Wal-Mart at Cutler

Administrative Amendment Request

Project #PR- 2021-005016

Transportation Development Comments:

DEMOLITION & SITE PLAN  
SHEET: CS1

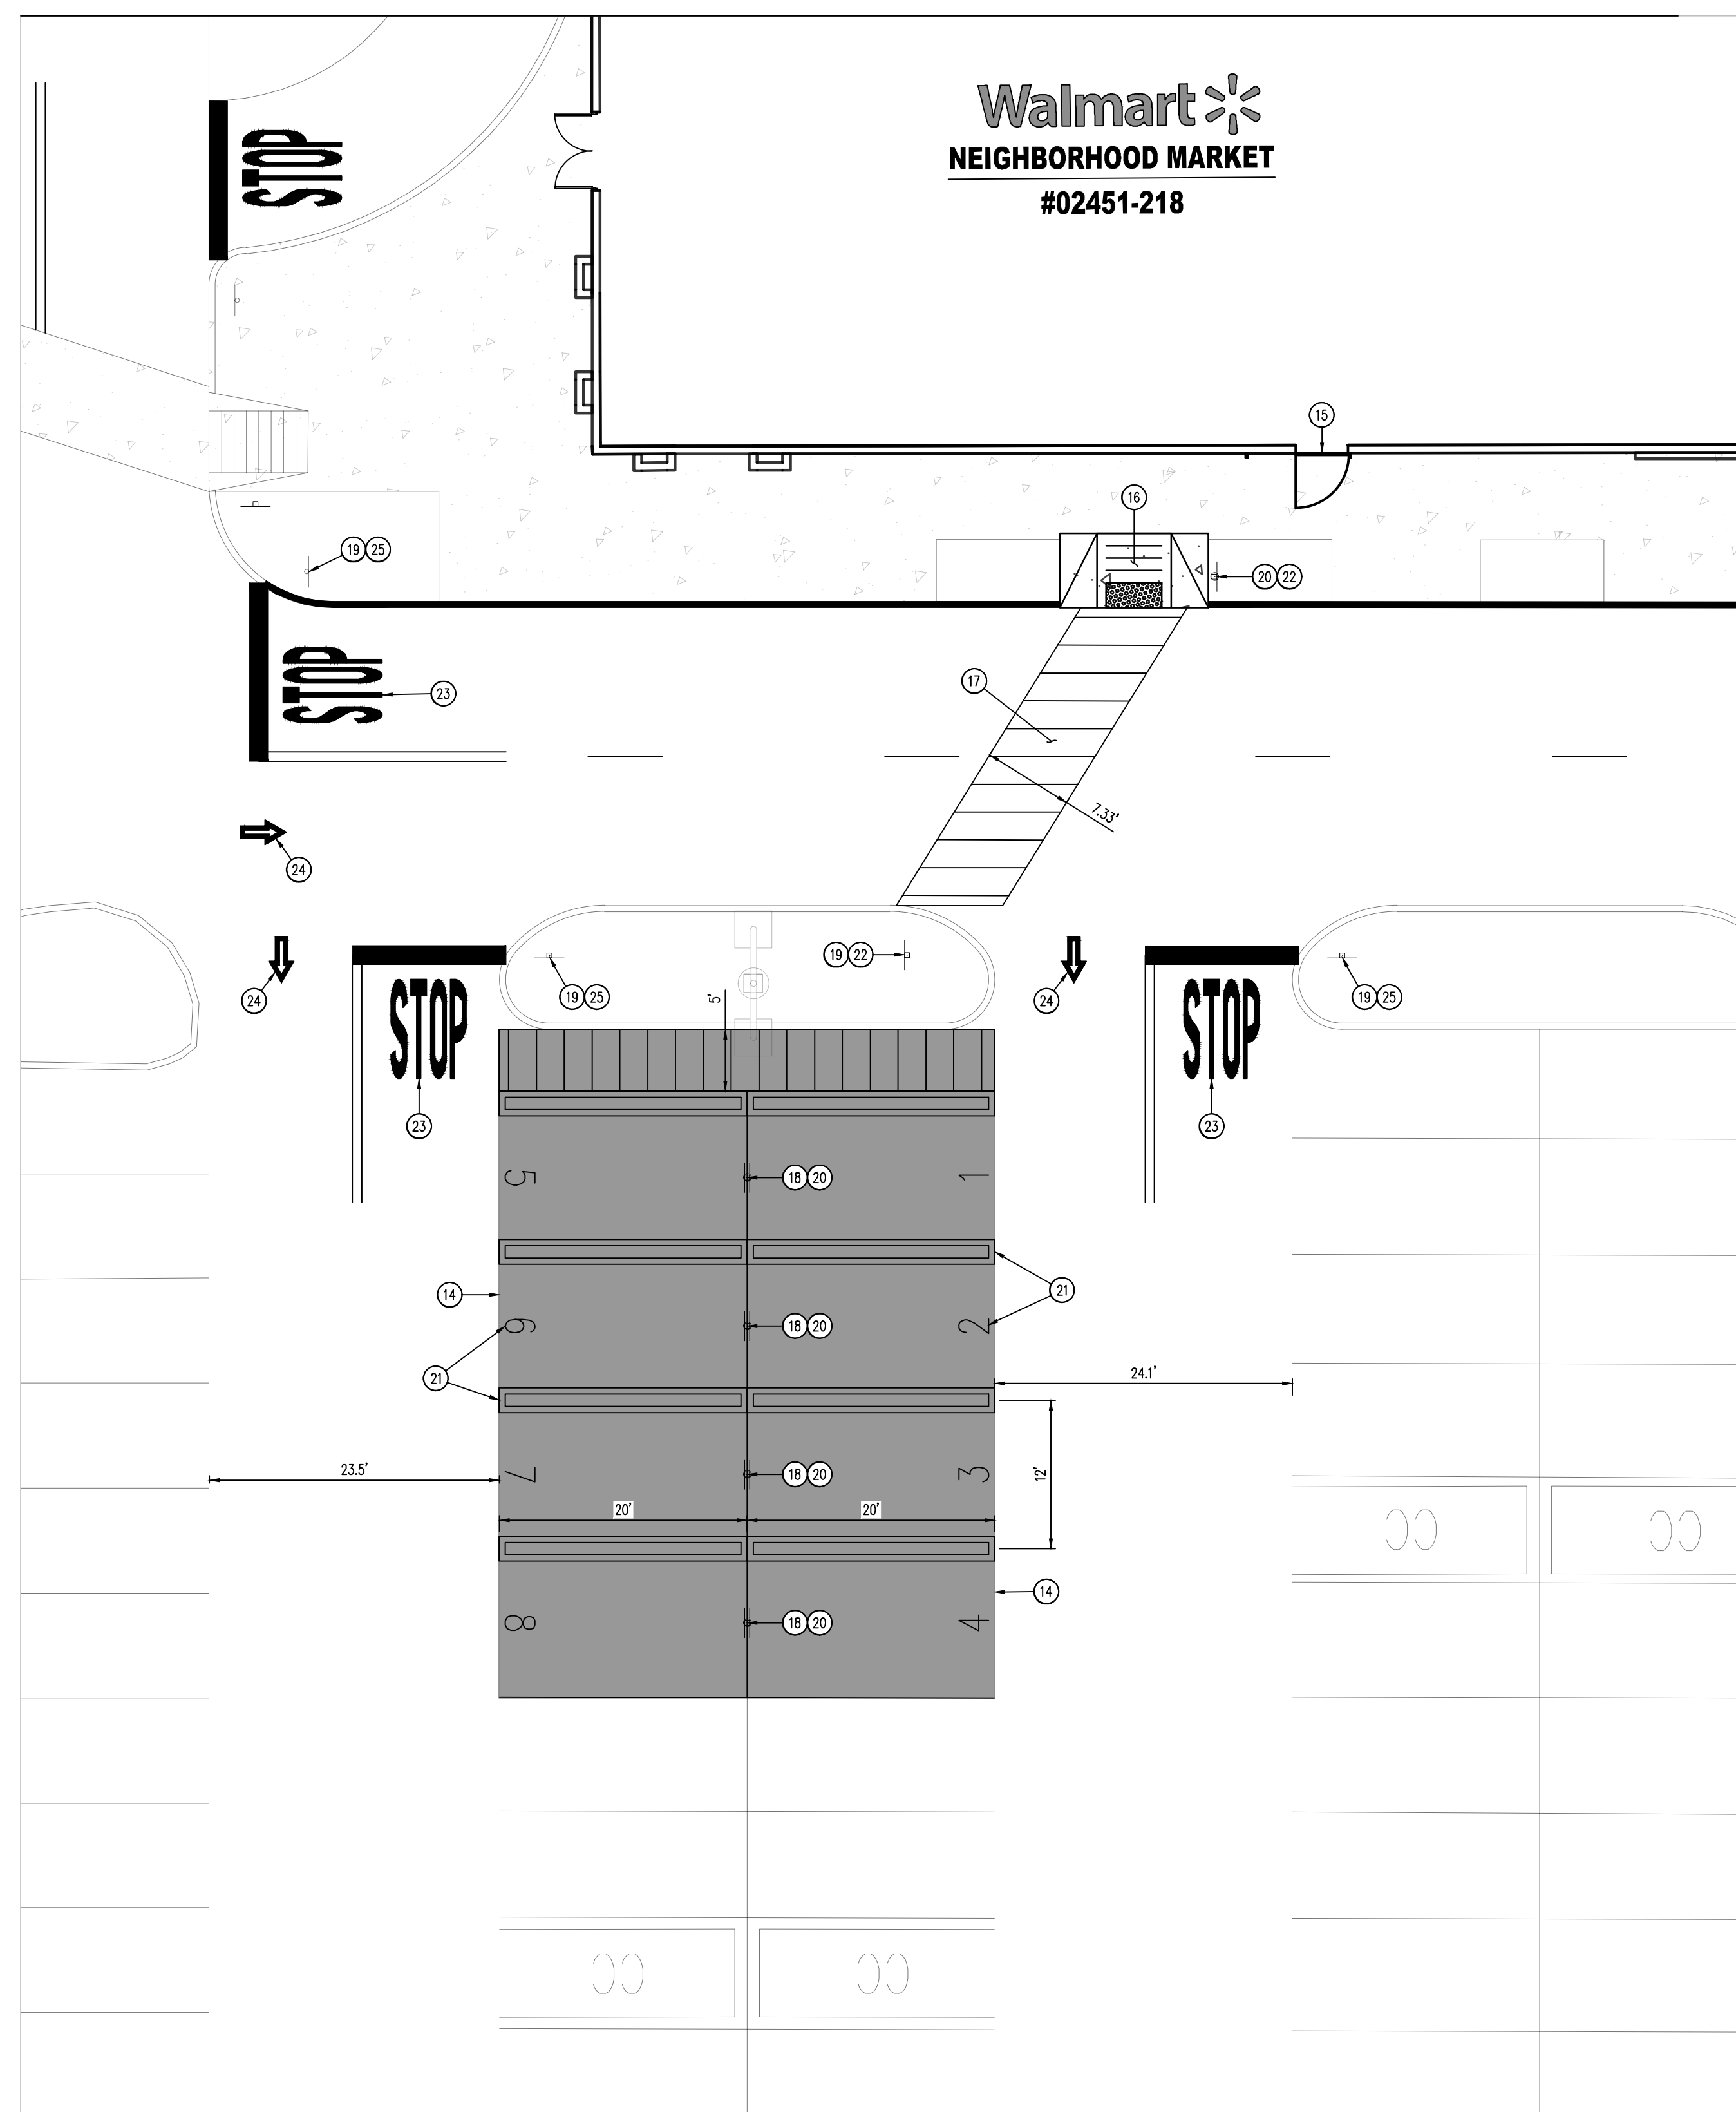
1. For centerline striping, the ratio of the gap to the stripe should be 3:1.
2. Provide "Yield to Pedestrian" signage on either side of the main crosswalk entrance per MUTCD requirements.
3. In the package, I did not see any details for signage and striping or a plan for parking spaces that involve pick-up only, similar to the other Wal-Mart packages. Please make sure to provide all plans.
4. Be sure to cross out keyed notes that are not used for this submittal. For any detail sheets provided, delete any signage that is not being used.
